Horizon

Lee 5 Honeysuckle

Design Report

2. State Design Review Panel - Meeting 01

North Elevation
Scale: 1:200

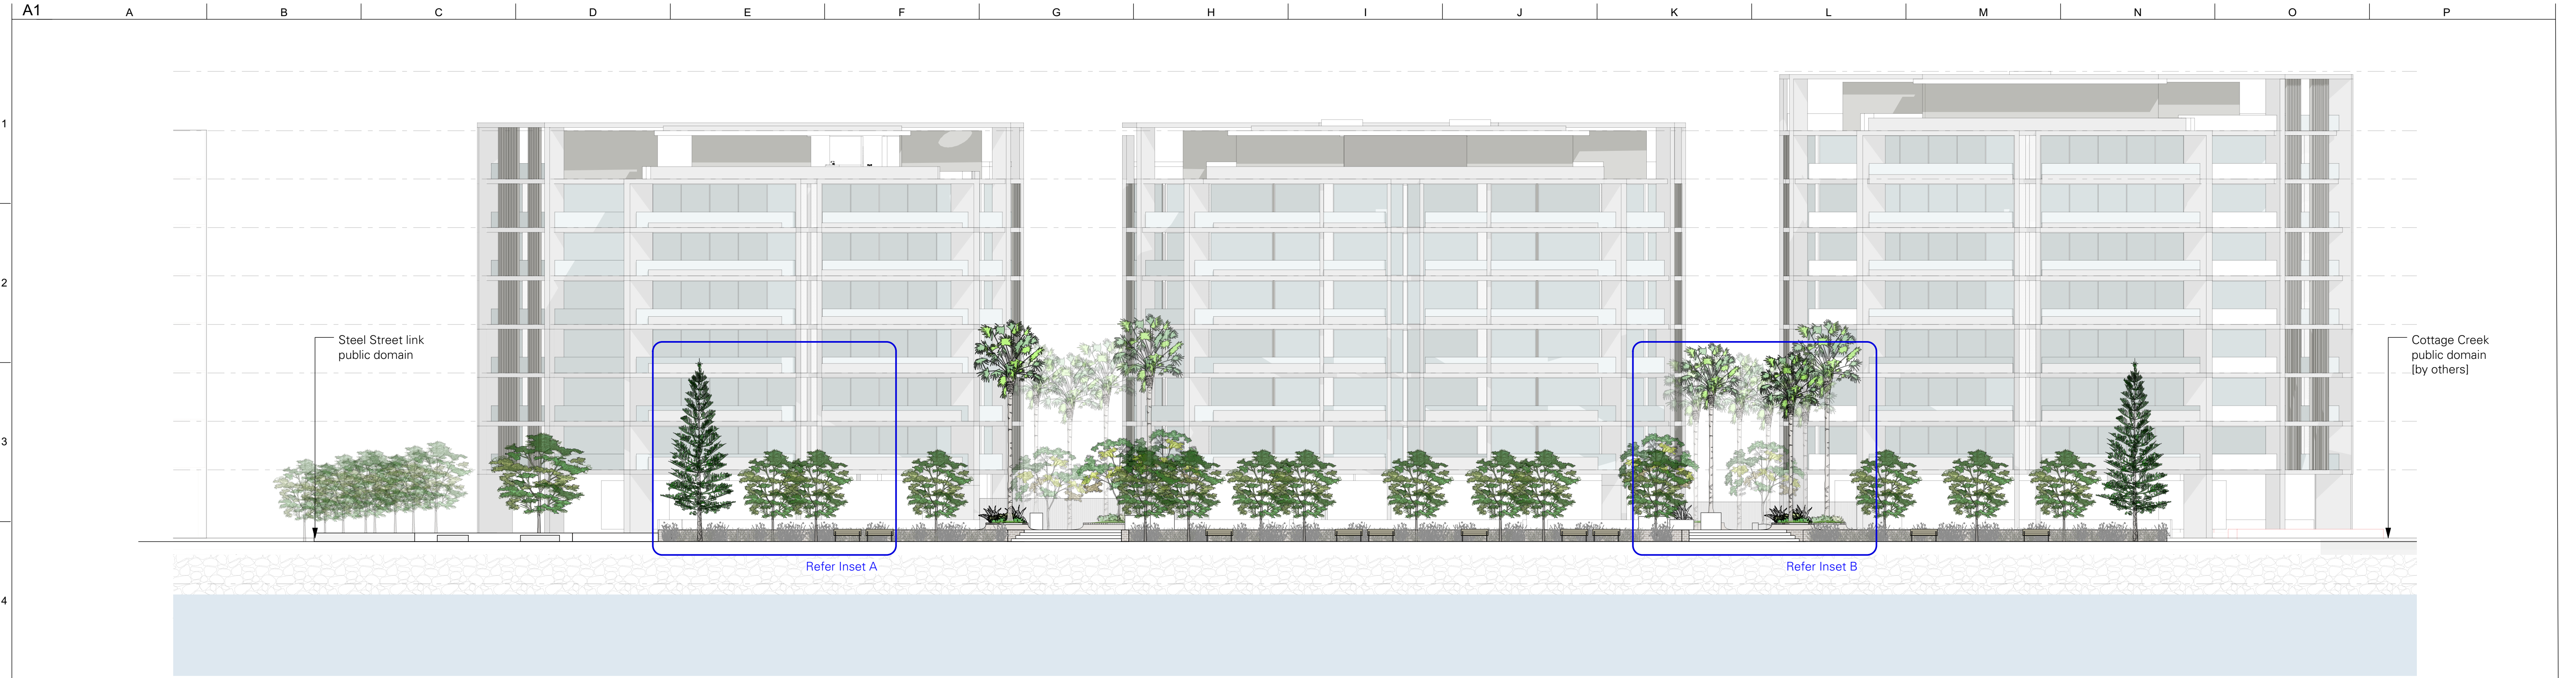
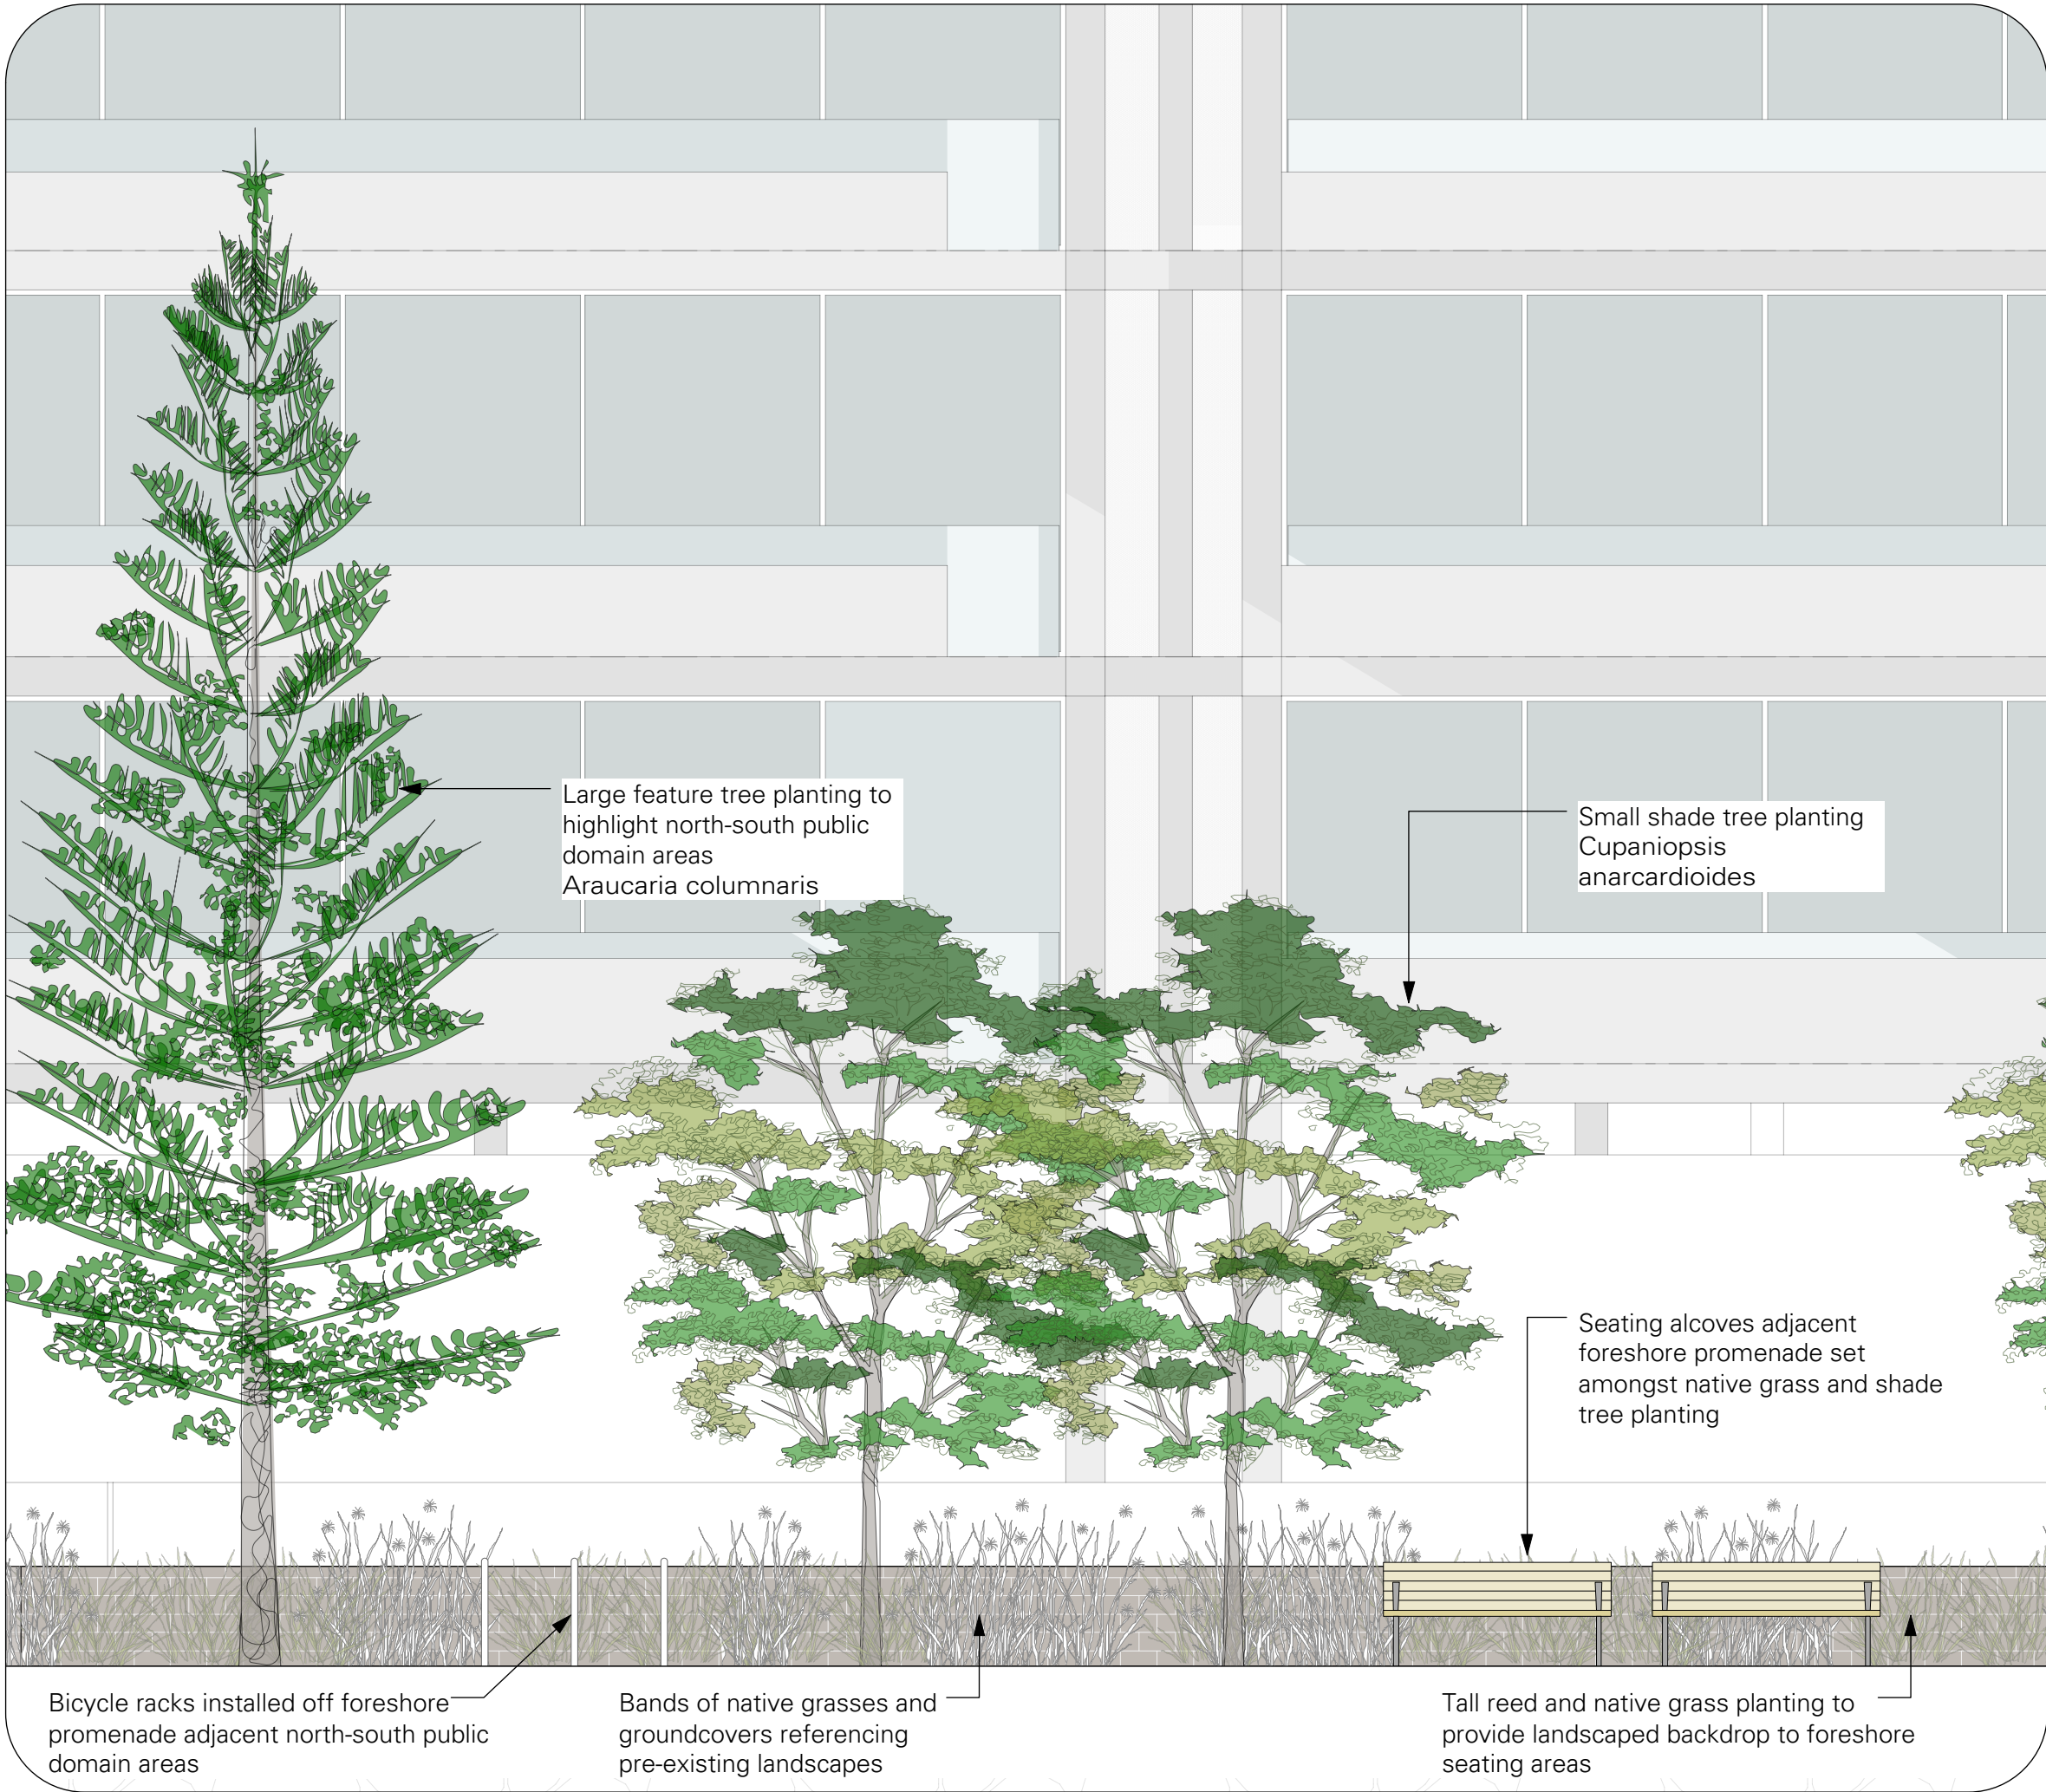
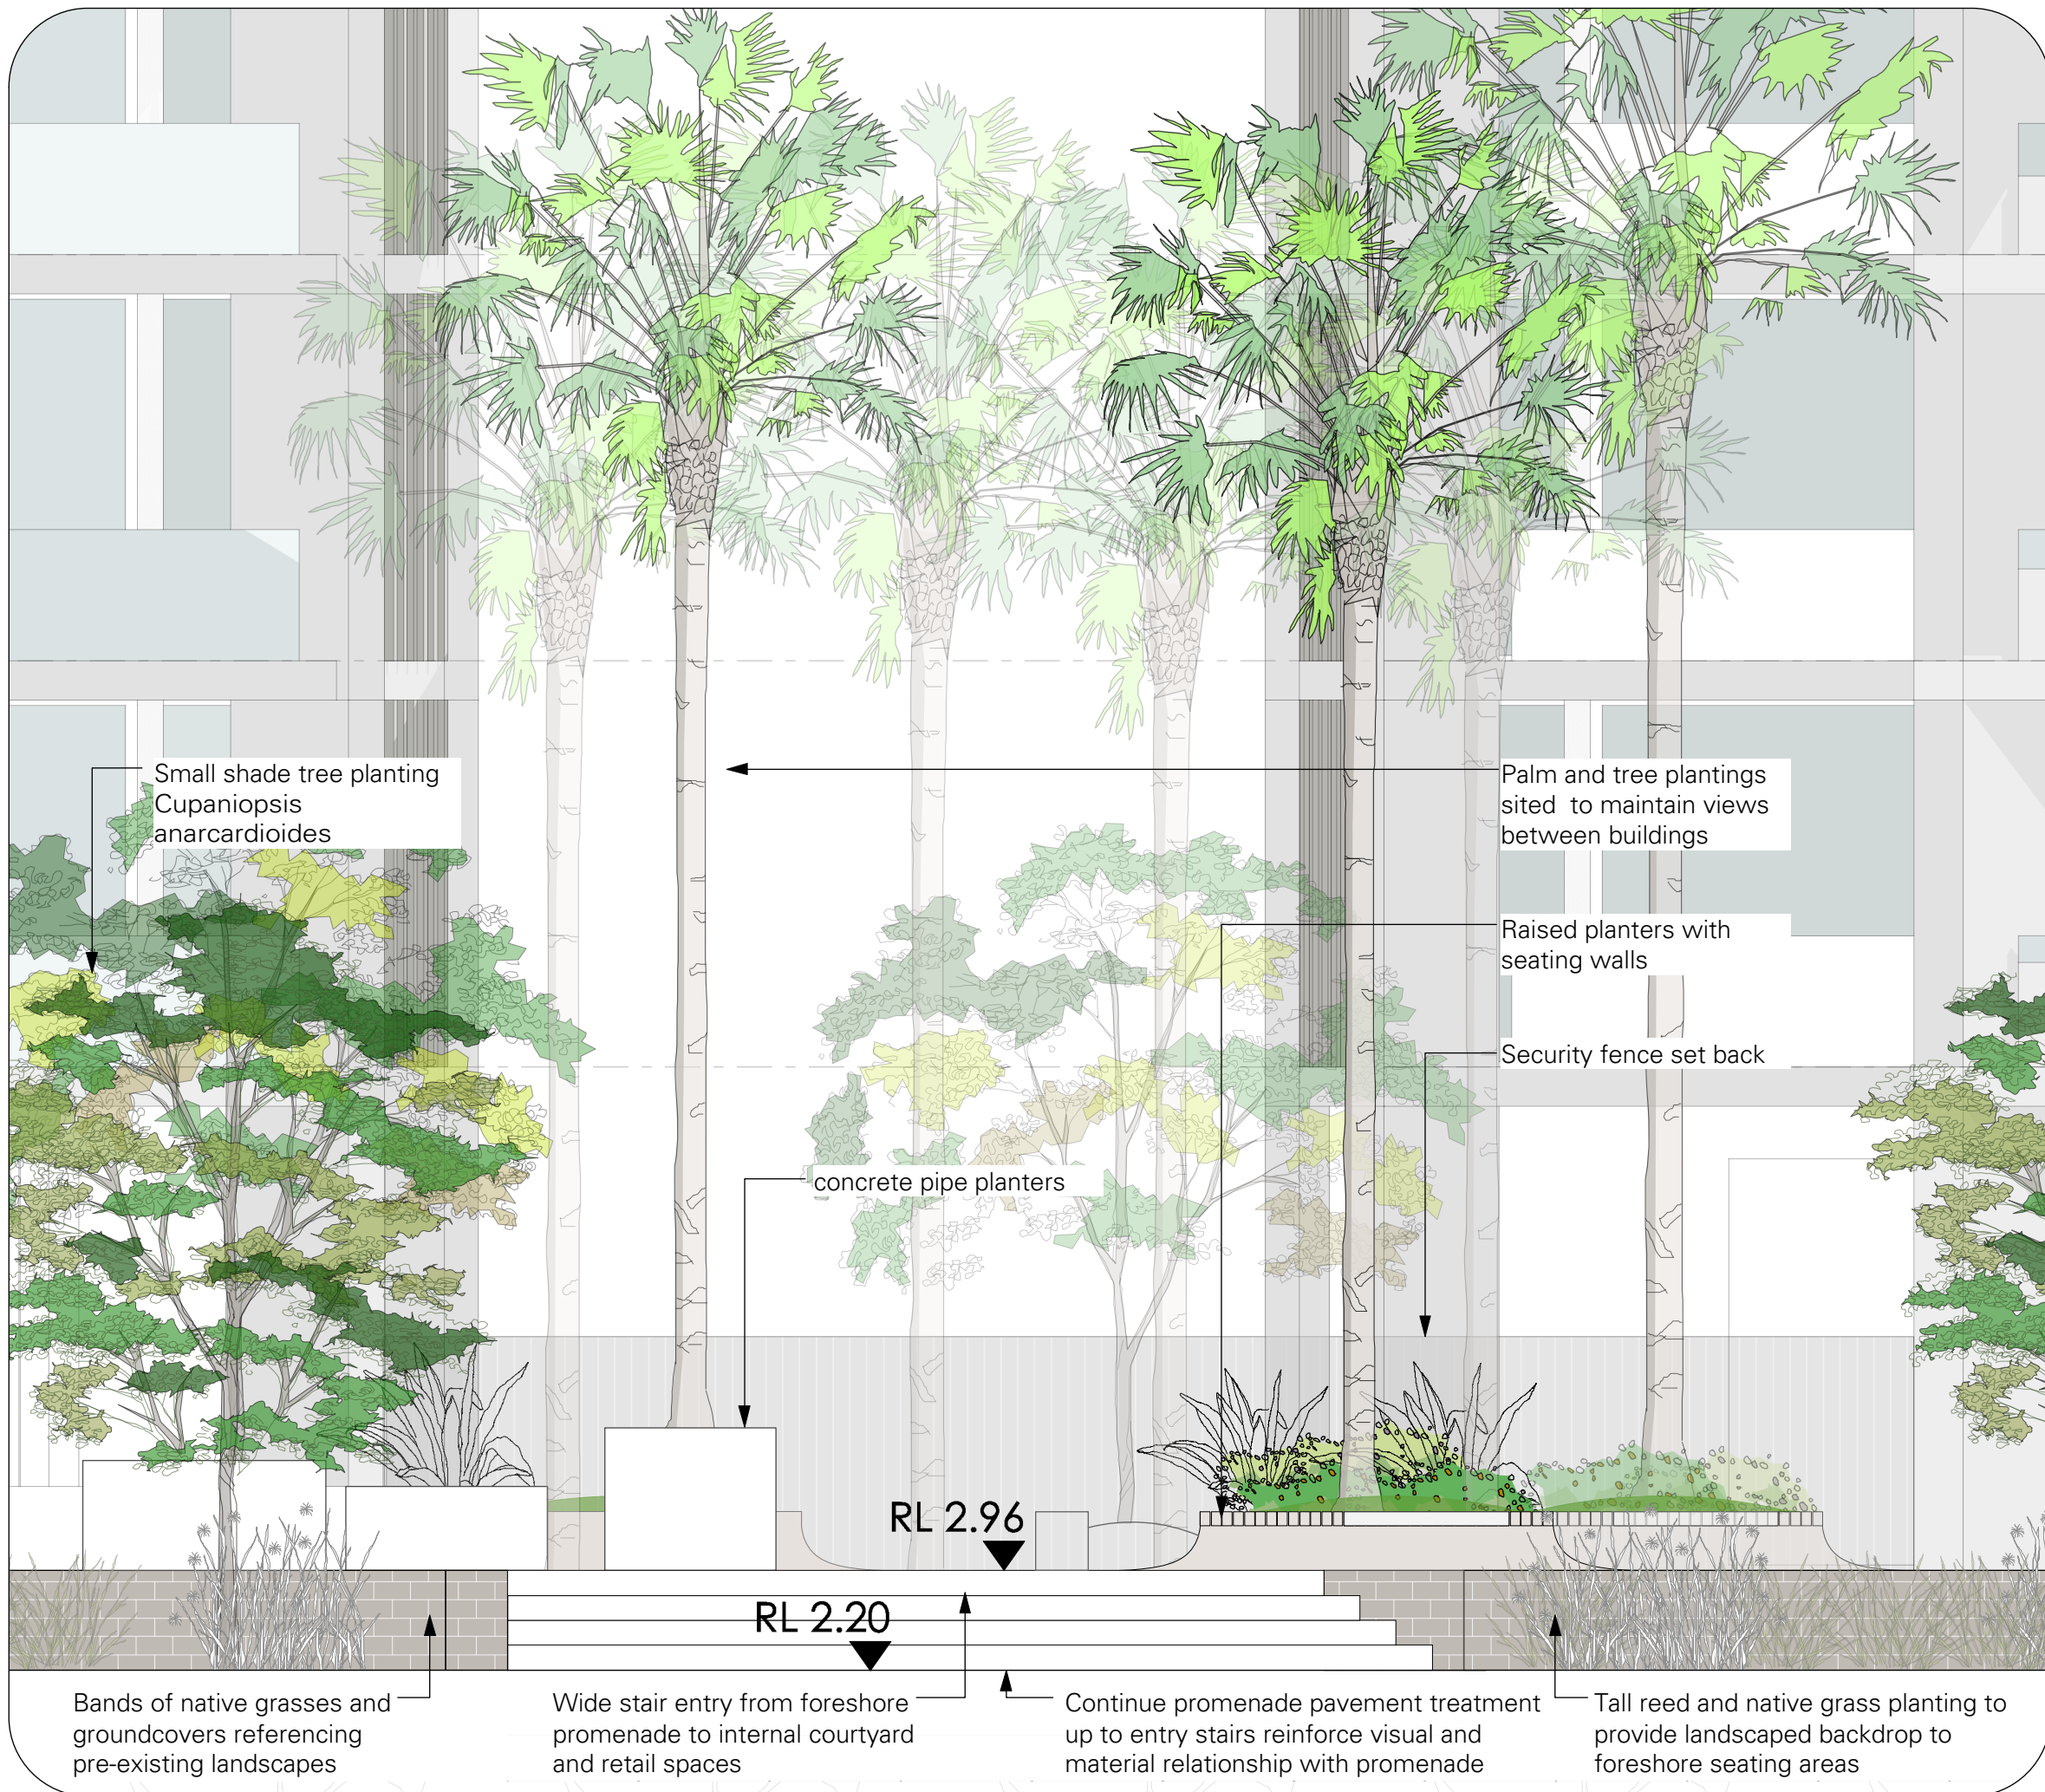
Further resolution and additional details are requested for the courtyard areas and the planter boxes along the foreshore. As currently illustrated the courtyard areas present as overly rigid in relation to the articulation of the building at the ground plane.

NORTH ELEVATION
SCALE 1:200 @ A1

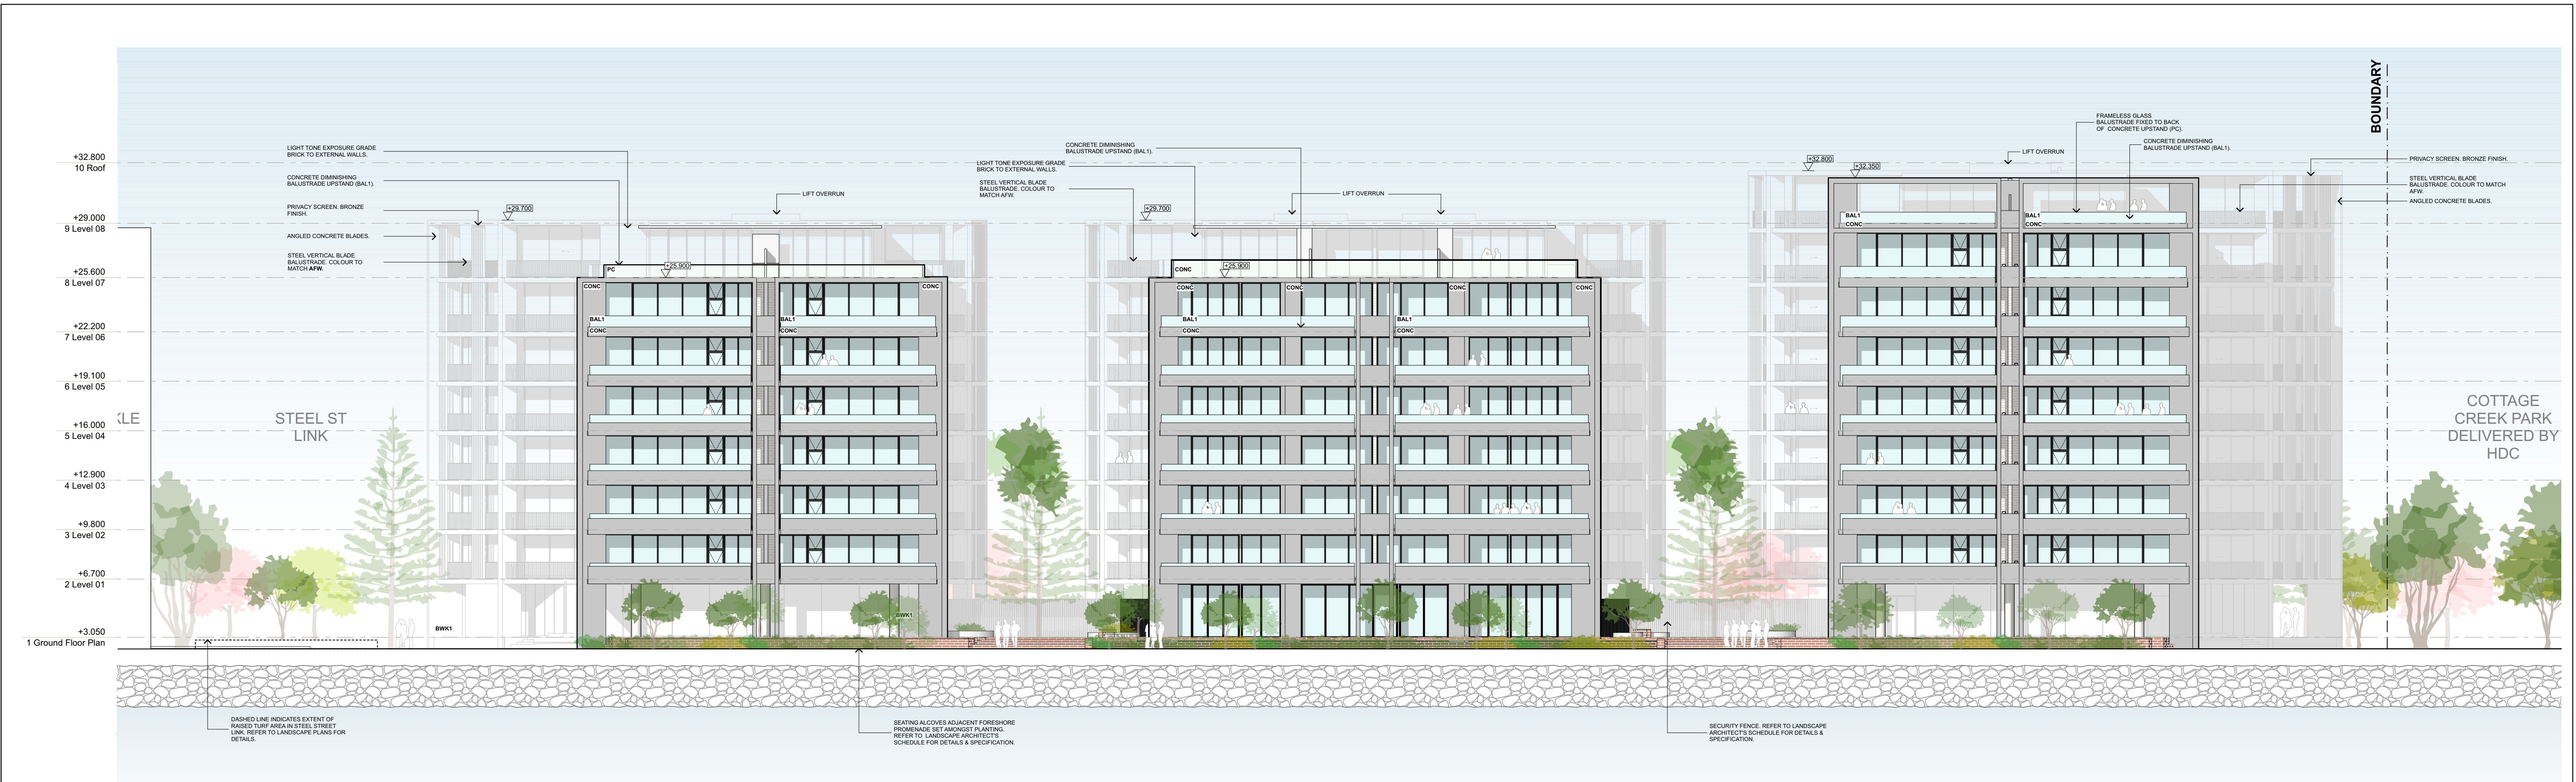
The panel commended the robust, well-mannered architectural character of the scheme. The elegant material palette was noted; panelists look forward to further resolution of the facades as the project develops. The weight of the north façade was supported, however brick masses on the south façade seemed unresolved. East and west facades are significant and need further design. Given the generous balconies, the panel suggested that partly solid balustrades would reduce reflectivity, improve privacy and enhance the outdoor room quality of these spaces. Sharp angular corners of balconies could also be resolved. Risks for the seaside location were discussed; the panel expressed concern that concrete elements are constructed by skilled contractors and to a high class finish. Wind will be an issue post occupation and should be carefully considered in the design of all façades.
